WEST SUSSEX COUNTY COUNCIL CONSULTATION

TO:	Arun District Council FAO: Amber Willard
FROM:	WSCC - Highways Authority
DATE:	2 July 2020
LOCATION:	26 Links Avenue Bognor Regis PO22 7BX
SUBJECT:	FP/81/20/HH Installation of a dropped kerb/crossover.
DATE OF SITE VISIT:	n/a
RECOMMENDATION:	More Information
S106 CONTRIBUTION TOTAL:	n/a

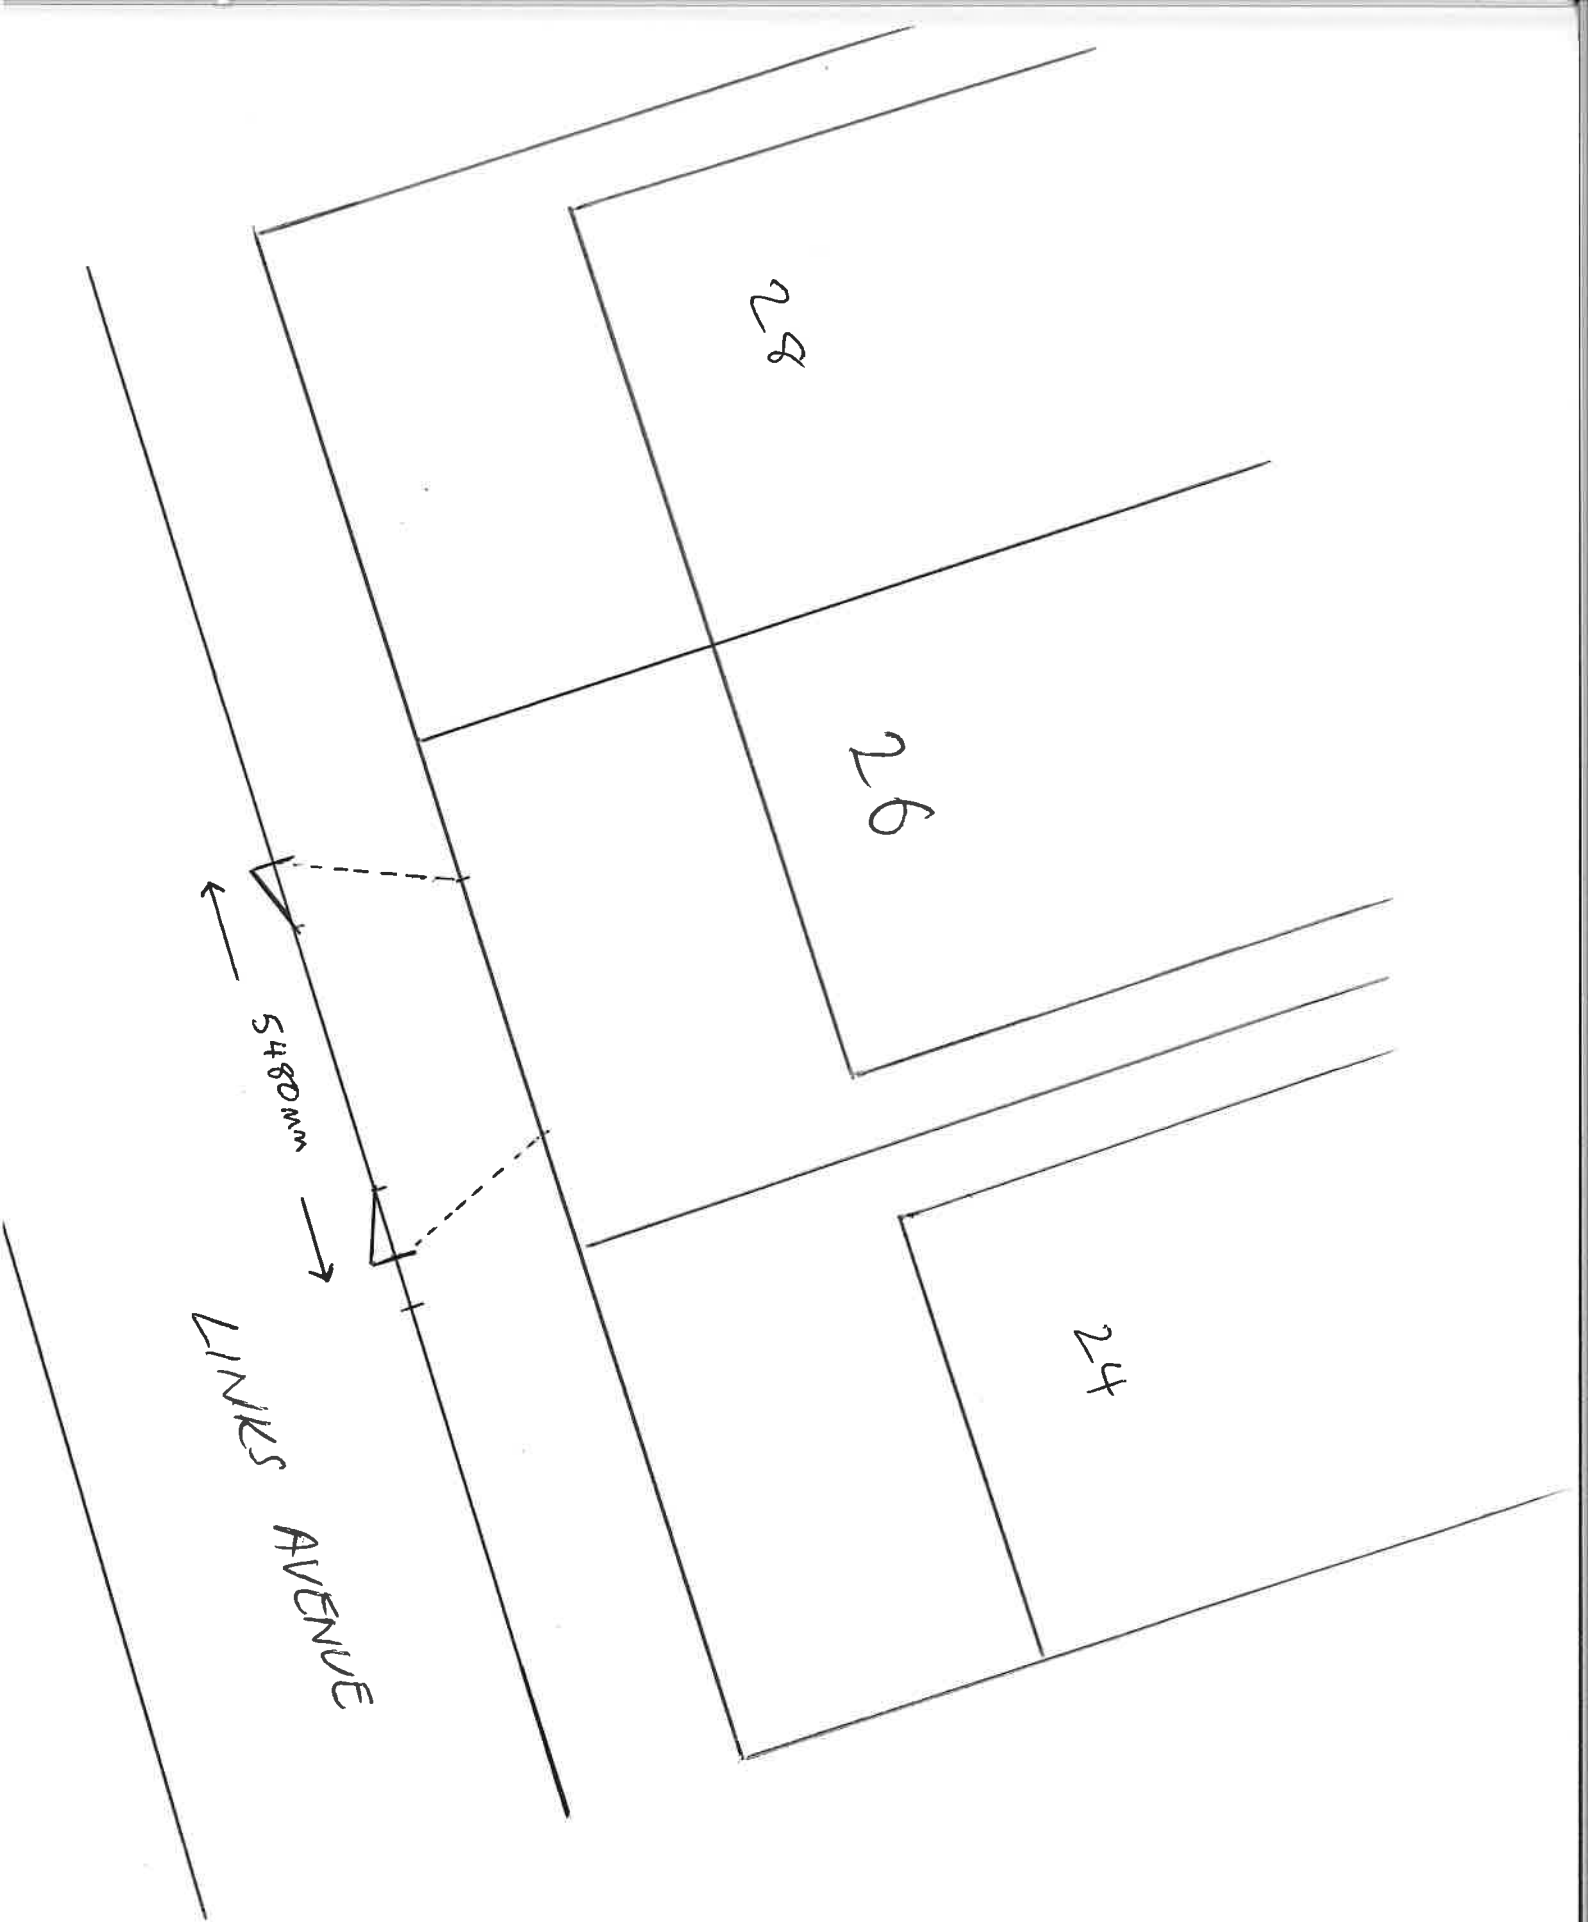
It is noted that the plan is annotated to demonstrate a 7.1 metre VCO.

The Local Planning Authority and the applicant should be mindful that the WSCC Highways Area Office, who is responsible for the issuing of VCO Licenses, do not wish to see VCO's measuring over 6.4 metres in this location due to the existing parking pressures and the loss of on-street parking provision for neighbouring residents. While

this is not a highways safety issue the LHA wish that good planning practices are kept and as such, no planning application is permitted where it cannot be implemented. As a result, the LHA advises the applicant to reduce the VCO to 6.4 metres maximum.

The applicant has not provided the dimensions of the parking area as described in the Design and Access Statement (D&A). The LHA requests the applicant provides such details following the below guidance.

The applicant should also note that the plans should demonstrate the location of the bay window and include a 2-metre exclusion zone abutting the front door to avoid obstruction for emergency access.
